**Daniel Douglas**  
**Team Leader Transport Planning**  
**Planning**  
London Borough of Havering  
Mercury House  
Mercury Gardens  
Romford  
RM1 3SL

**London Borough of Havering (20025659) – LB Havering response to Outline Traffic Management Plan (REP7-017)**

Appendix E: Petersfield Avenue vehicle swept path analysis

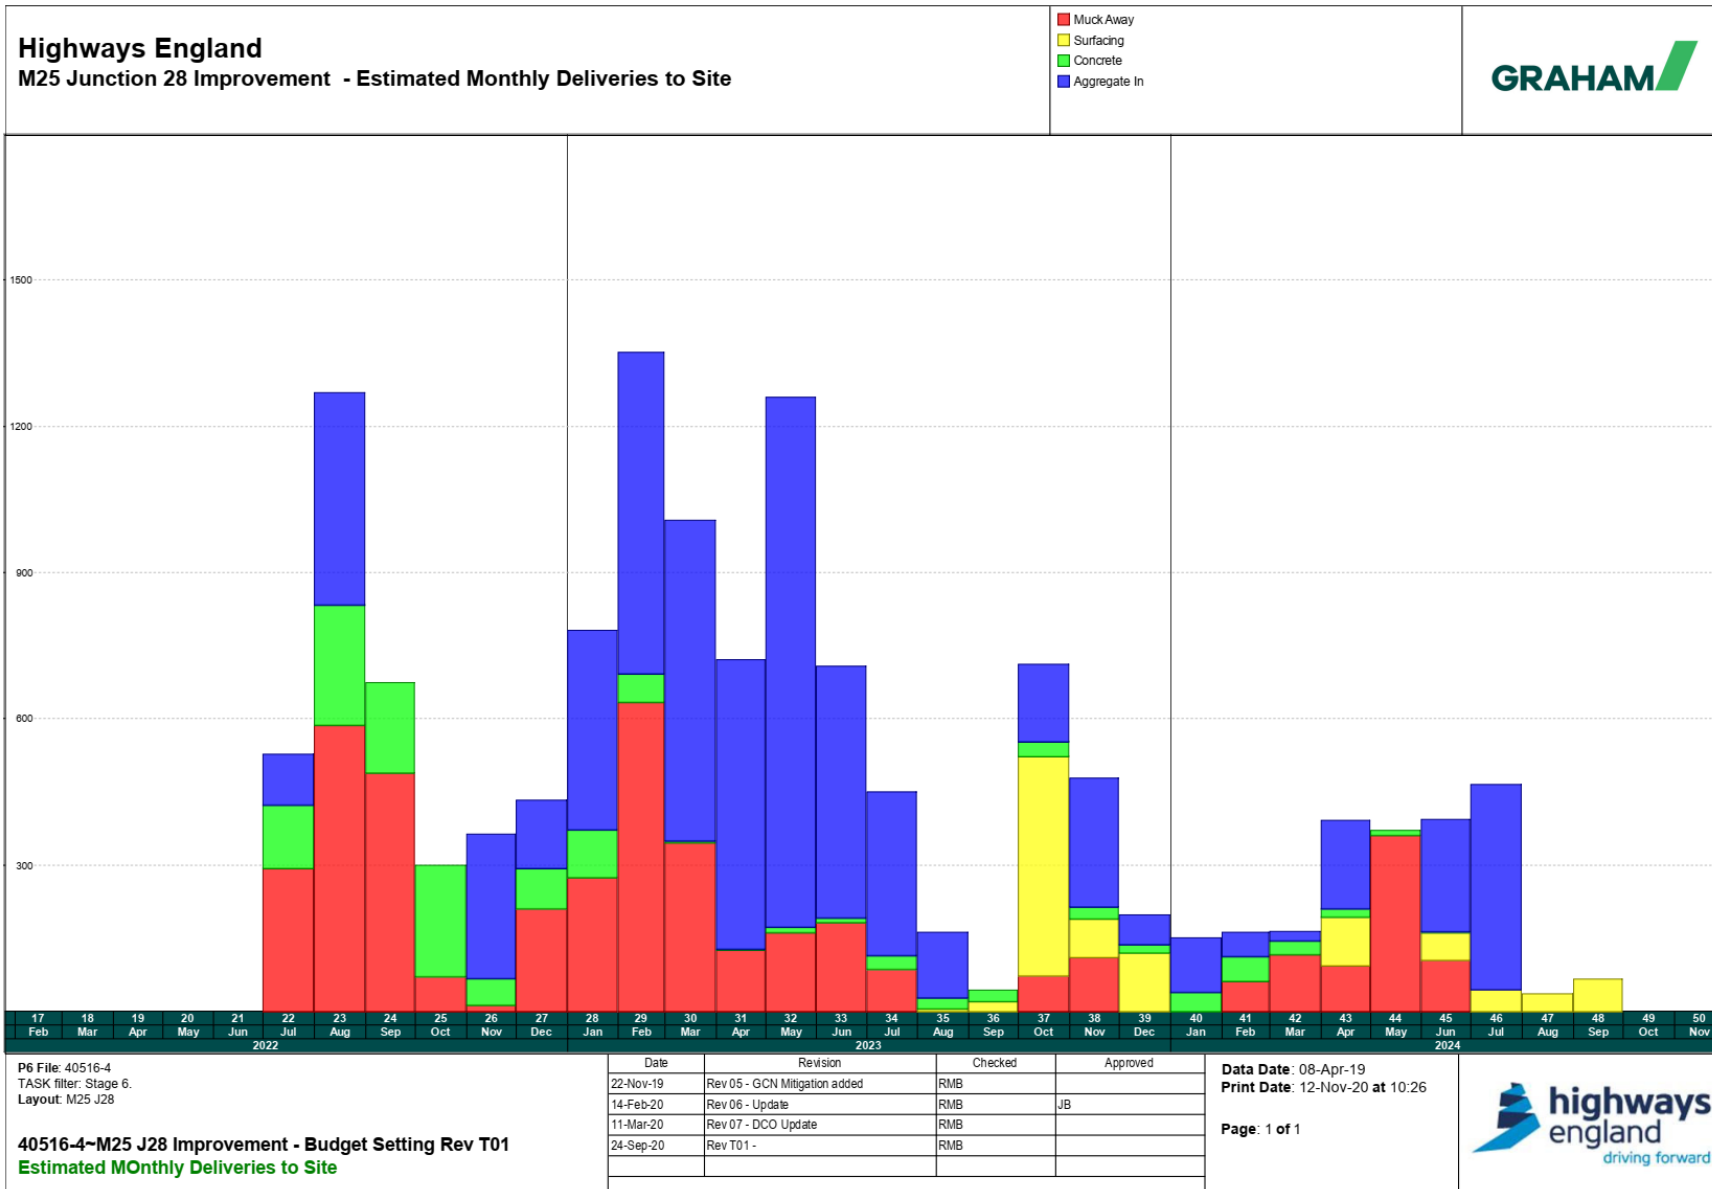
We would wish to have explicit reference to all construction traffic not using the Petersfield Avenue junction as a site access route. Signing solely for preventing HGV movements will create doubts in driver's minds; a complete prohibition would appear more pragmatic.
